Subject: FG/36/26/L

Home Farm House 63 Ferringham Lane, Ferring, BN12 5LL

Application for, building consent for replacement of windows and rear door with timber-framed double-glazed units.

Client:	JANE CHEAL
Project:	Home Farm House 63 Feelingham Lane, Ferring
Drawing Title:	Window Details
Scale:	No Scale
Date:	18/3/2026

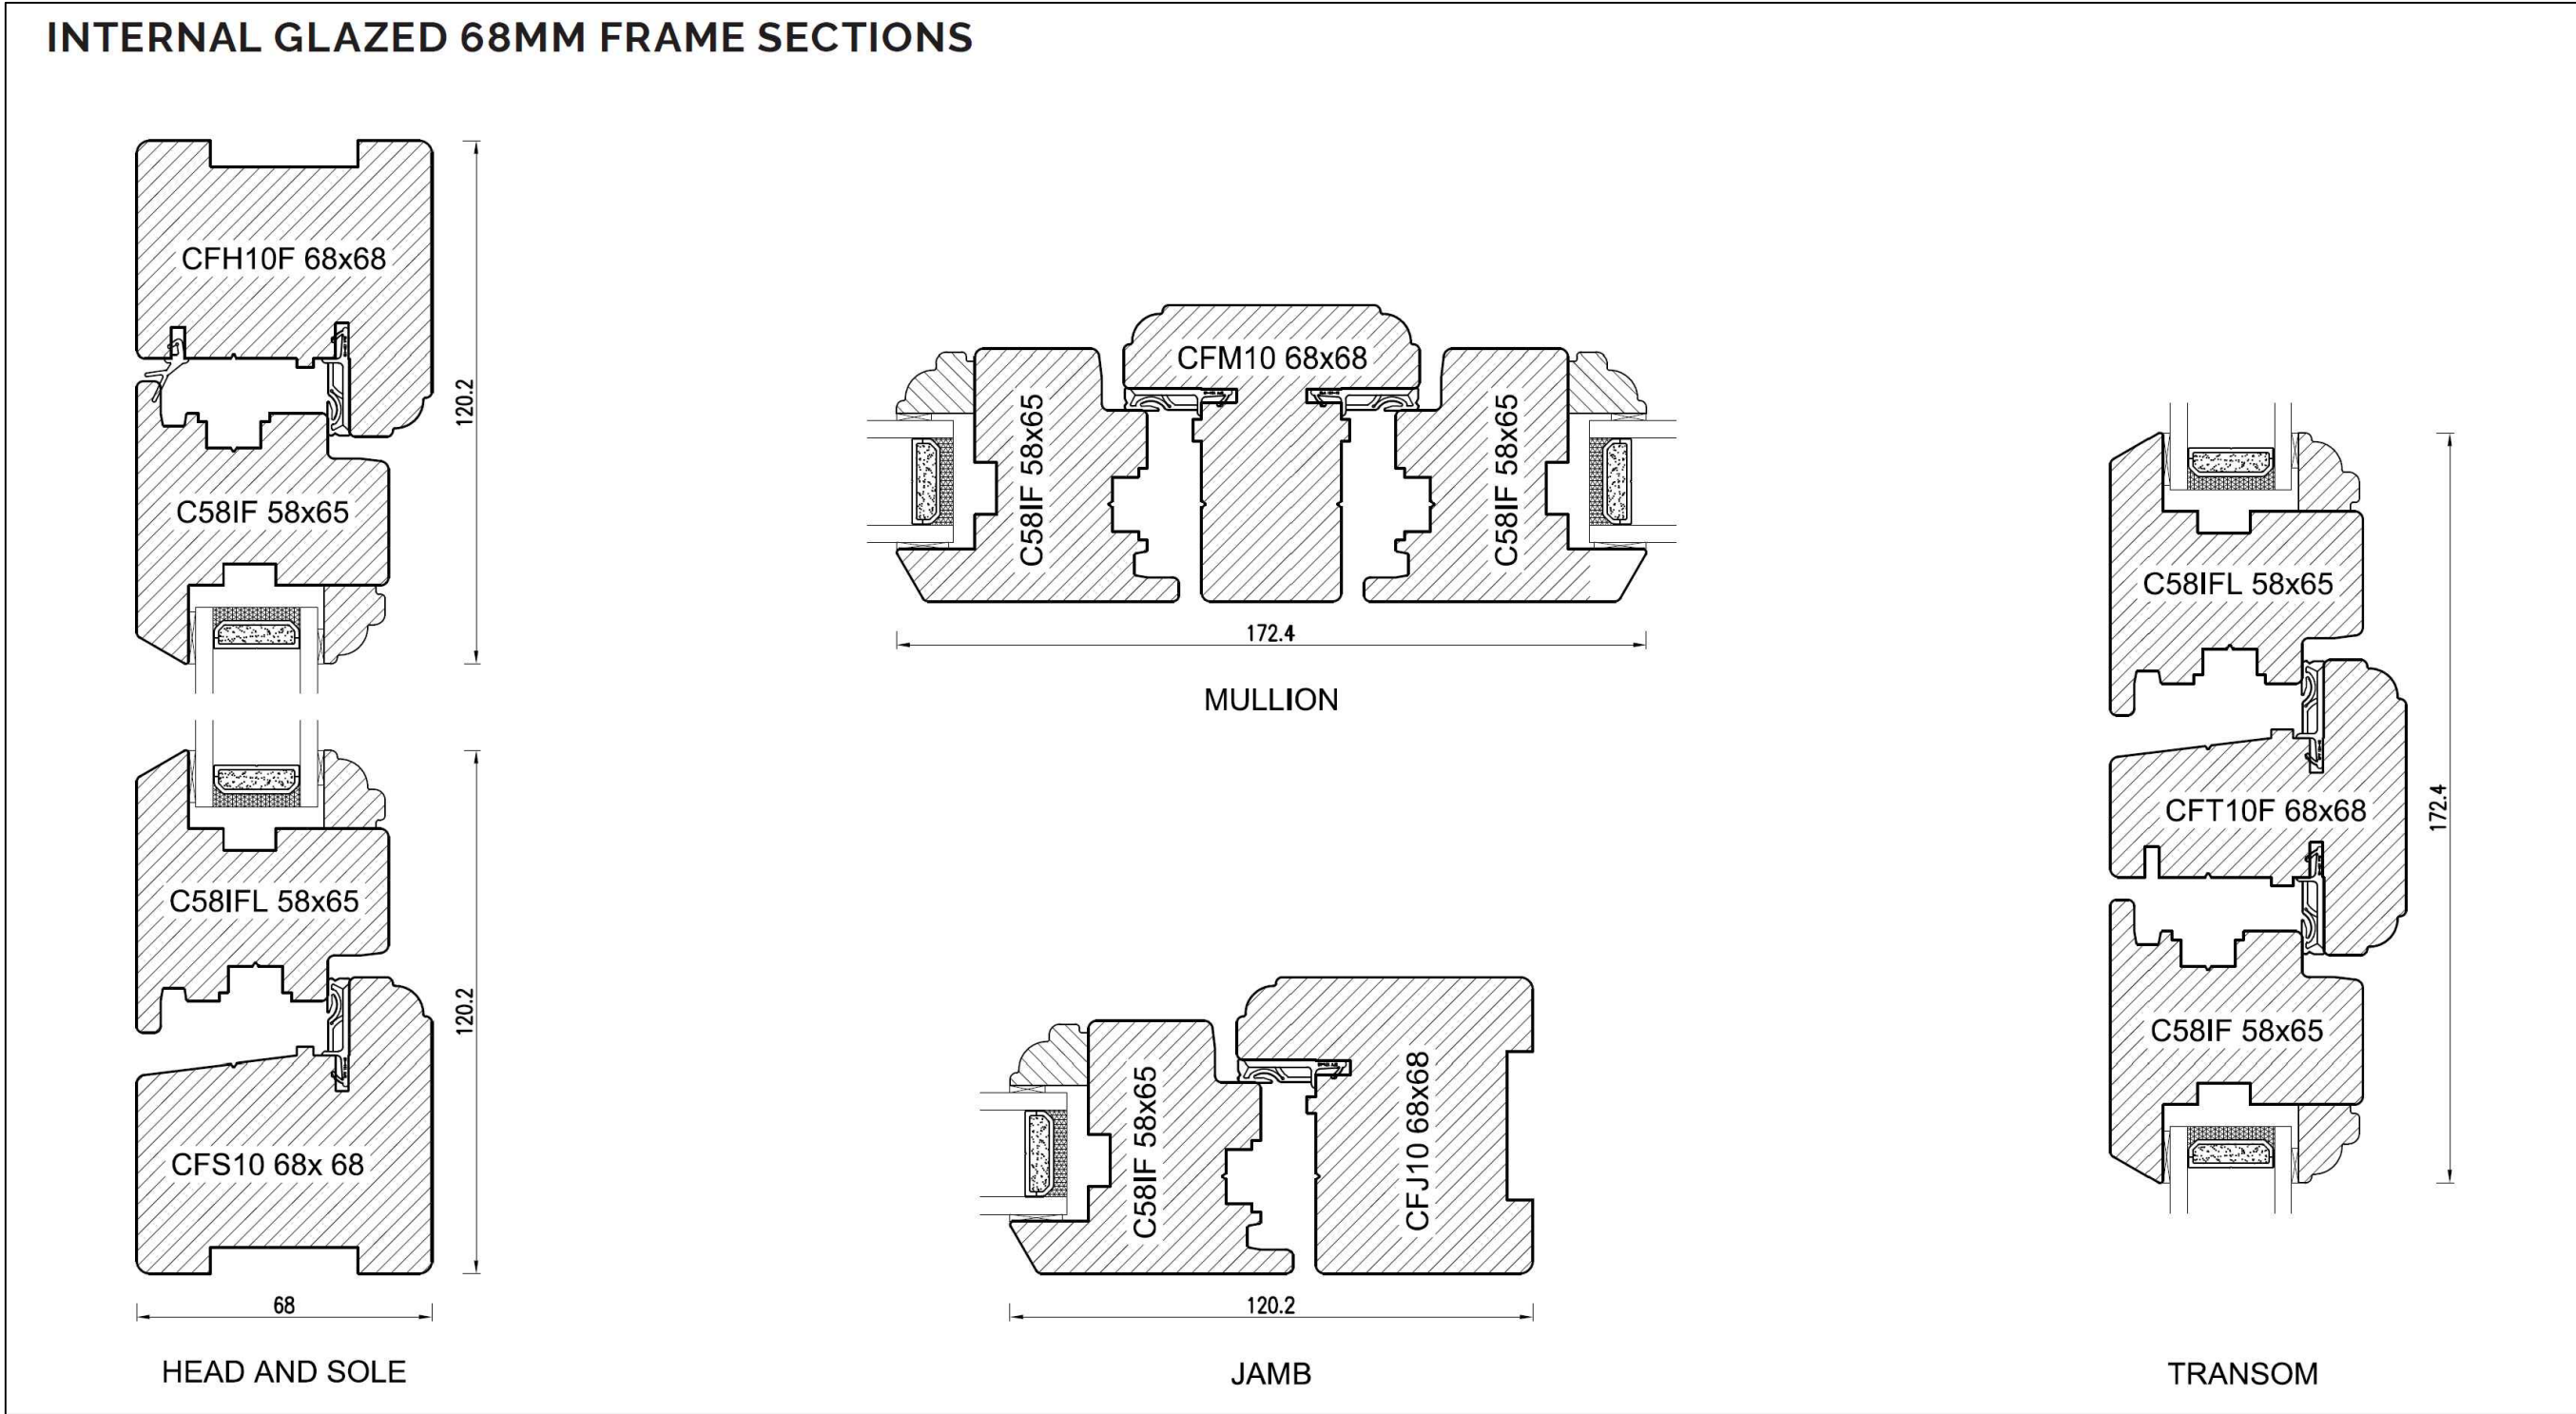
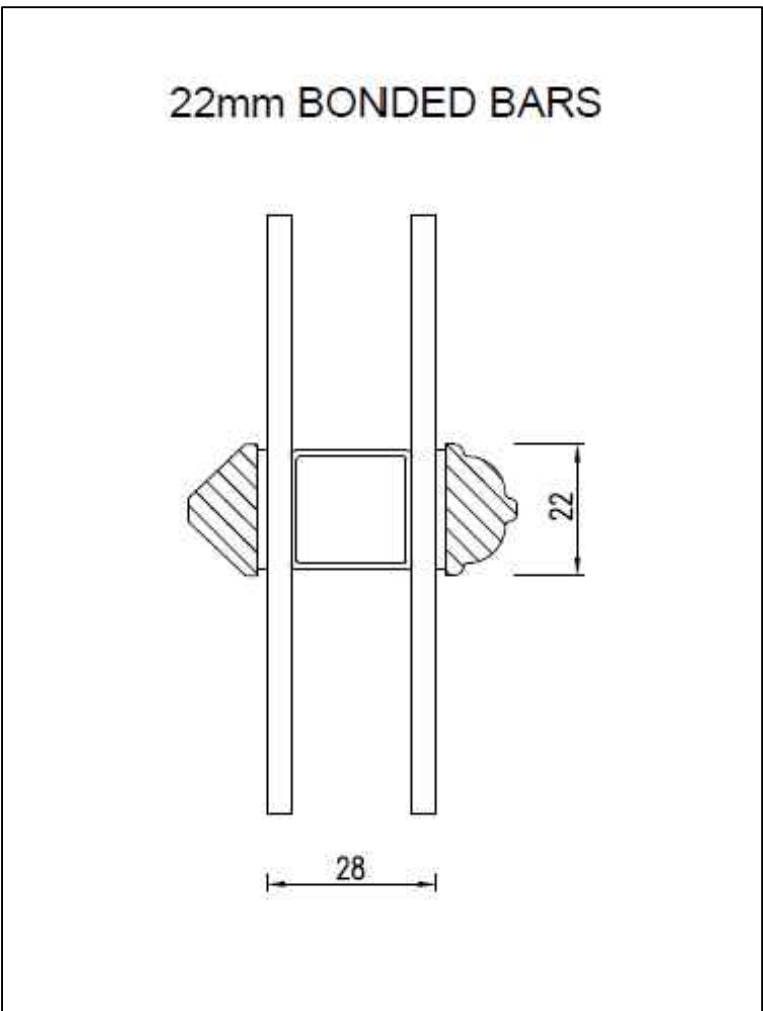
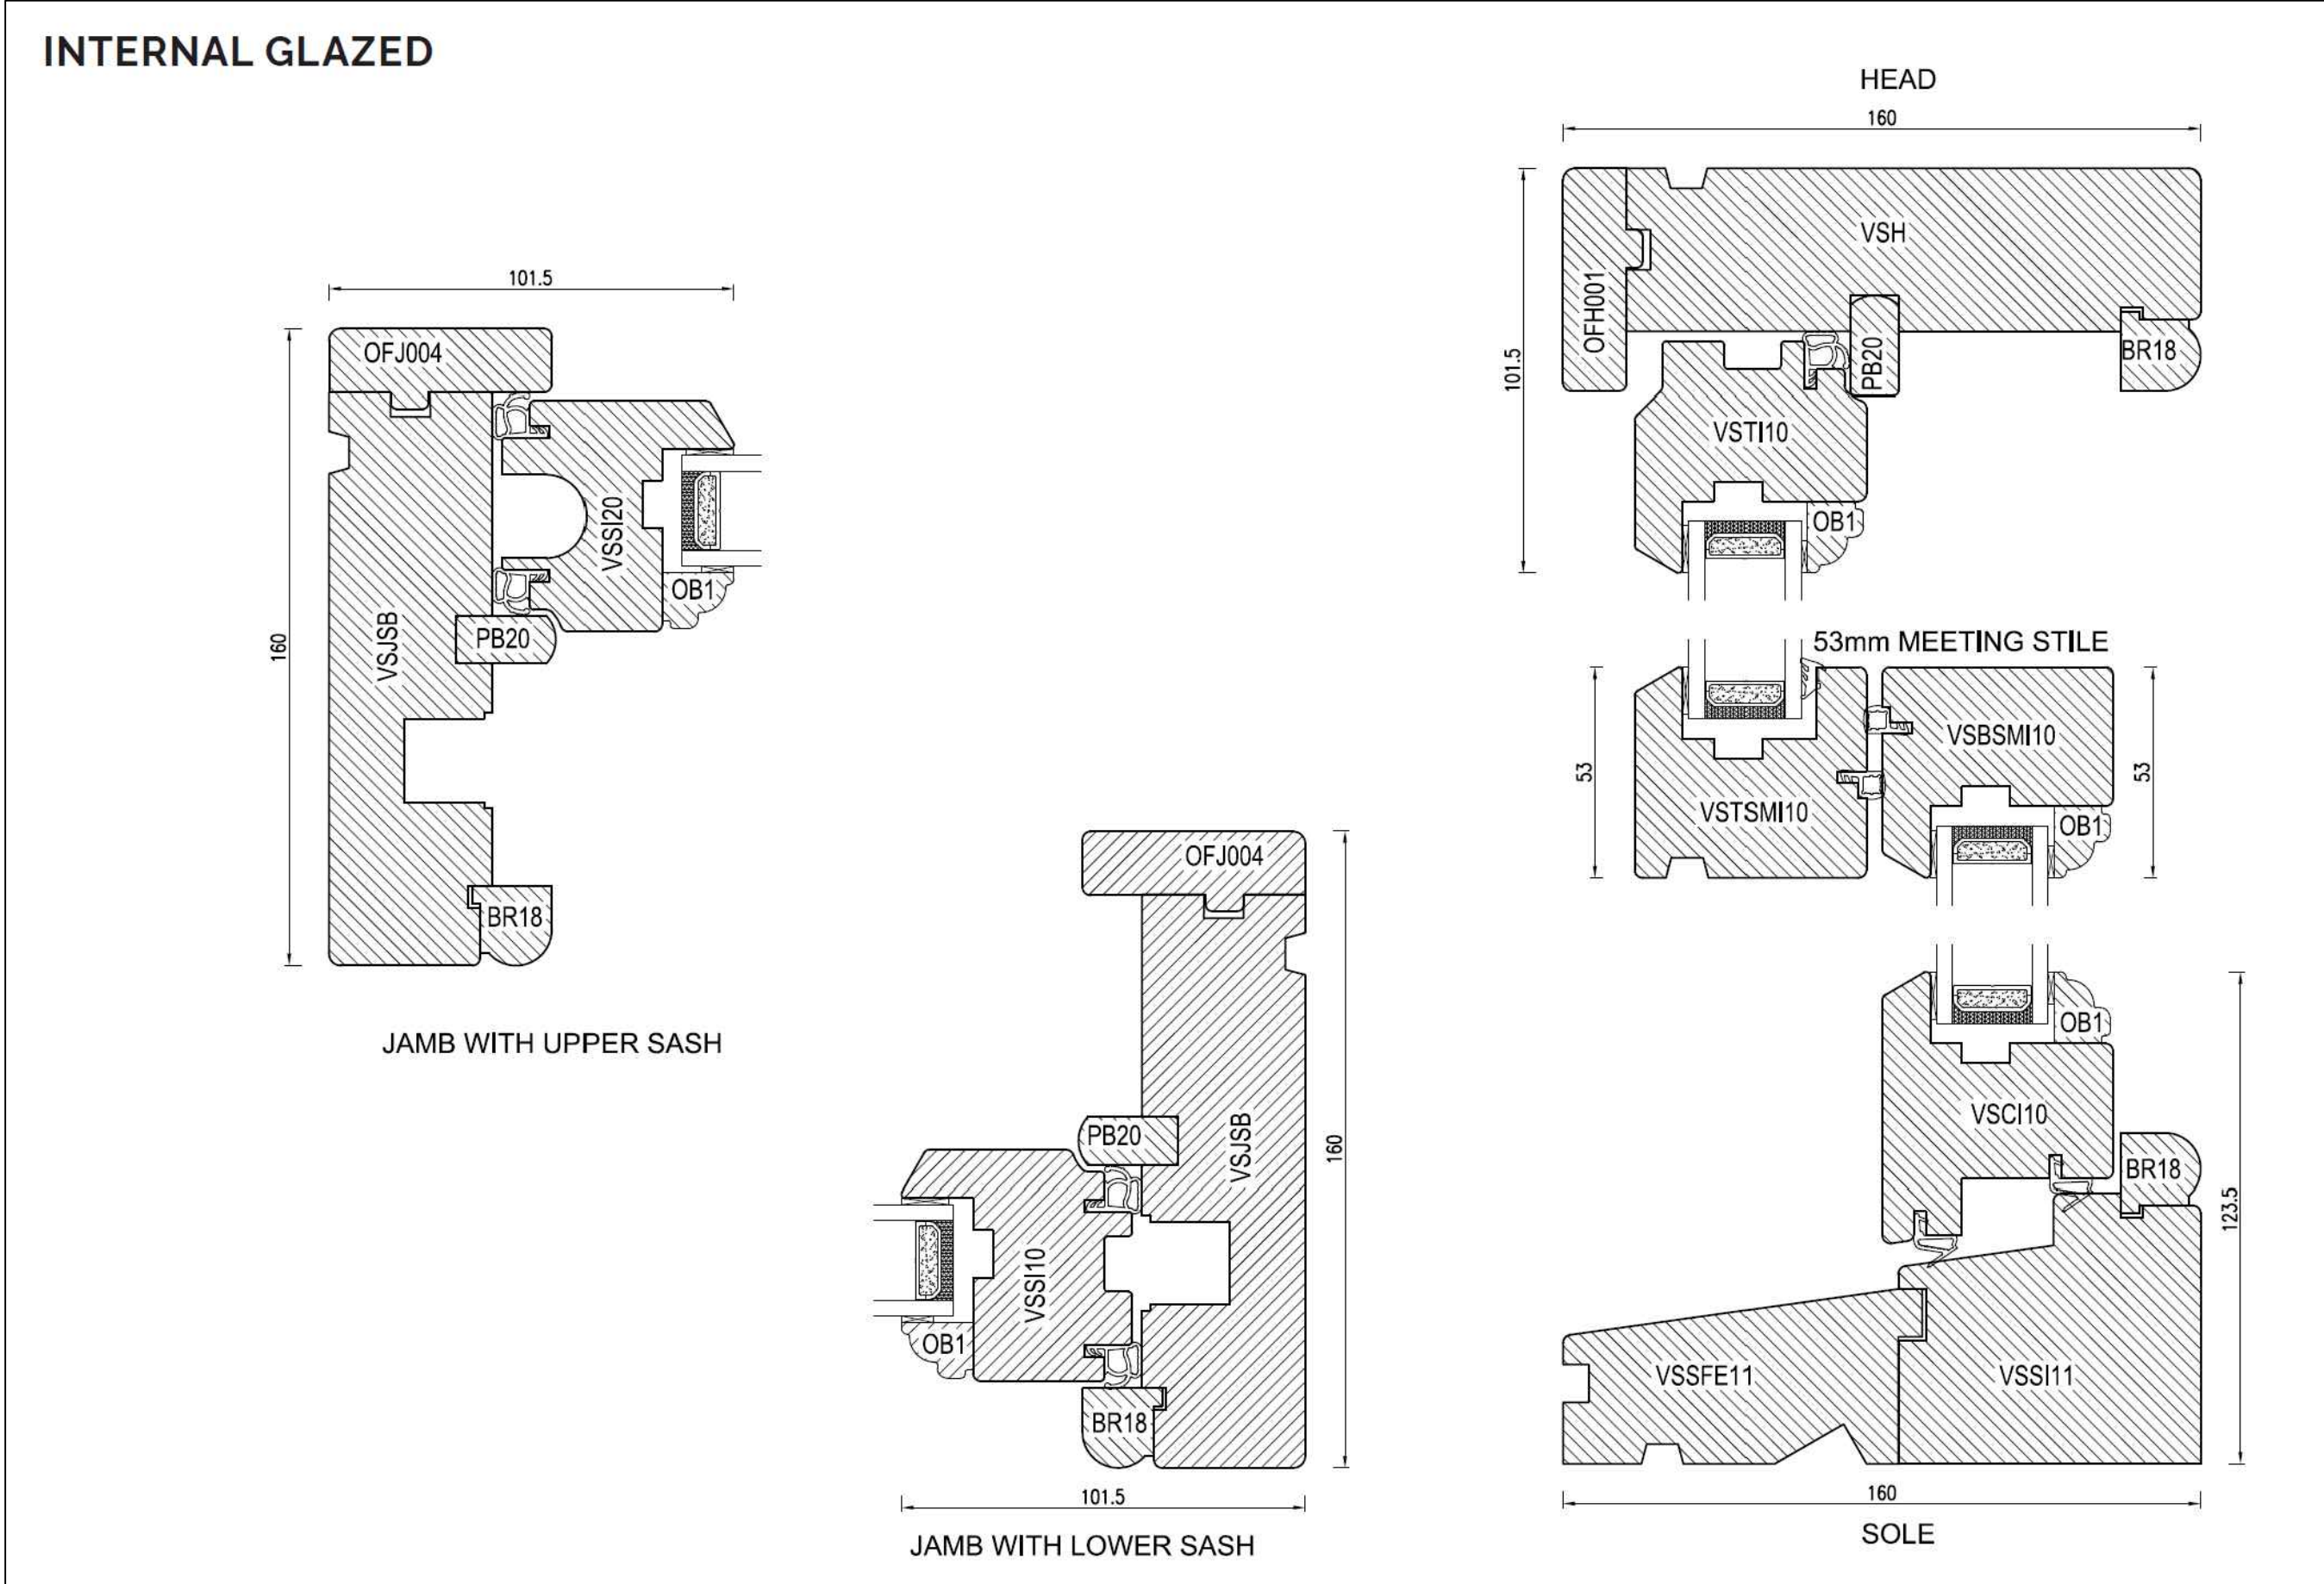
In this case, the proposed use of standard 28mm double-glazed units is not considered appropriate. While the objective of improving thermal performance is acknowledged, such units are inherently incompatible with traditional joinery. Their thickness necessitates increased section sizes and the use of applied glazing bars, resulting in detailing that is fundamentally at odds with traditional construction and leading to a loss of the fine characteristics associated with historic windows.

In respect of the principal elevation, the proposal would result in the loss or substantial alteration of traditional sash windows, which are specifically identified within the statutory list description as retaining intact glazing bars. The introduction of 28mm units would require a fundamental change to the proportions, section sizes and detailing of the sashes, resulting in harm to fabric that contributes directly to the building's significance.

With regard to the rear elevation, it is acknowledged that the existing windows are of modern origin. However, this does not remove the requirement for appropriate design within a listed building. The use of standard 28mm double-glazed units would still result in joinery sections and applied detailing that are visually inconsistent with traditional construction and the established character of the building.

A more appropriate approach would be the use of slim-profile double glazing or other conservation-led solutions that better replicate traditional construction, supported by accurate sectional drawings and detailed joinery specifications. No such solution has been provided. The submitted window details reinforce these concerns, indicating the use of standard double-glazed units with applied astragal bars of approximately 22mm in width, together with modern construction methods such as internal glazing and spiral balances. These are not characteristic of traditional historic joinery, where glazing bars are significantly finer and form an integral structural component of the sash.

While it is suggested that the frames and glazing bars would maintain traditionally slim profiles, this is not supported by the proposed 28mm glazing specification. The physical requirements of such units inevitably result in thicker sections and altered detailing, and the resulting appearance would differ materially from traditional examples.
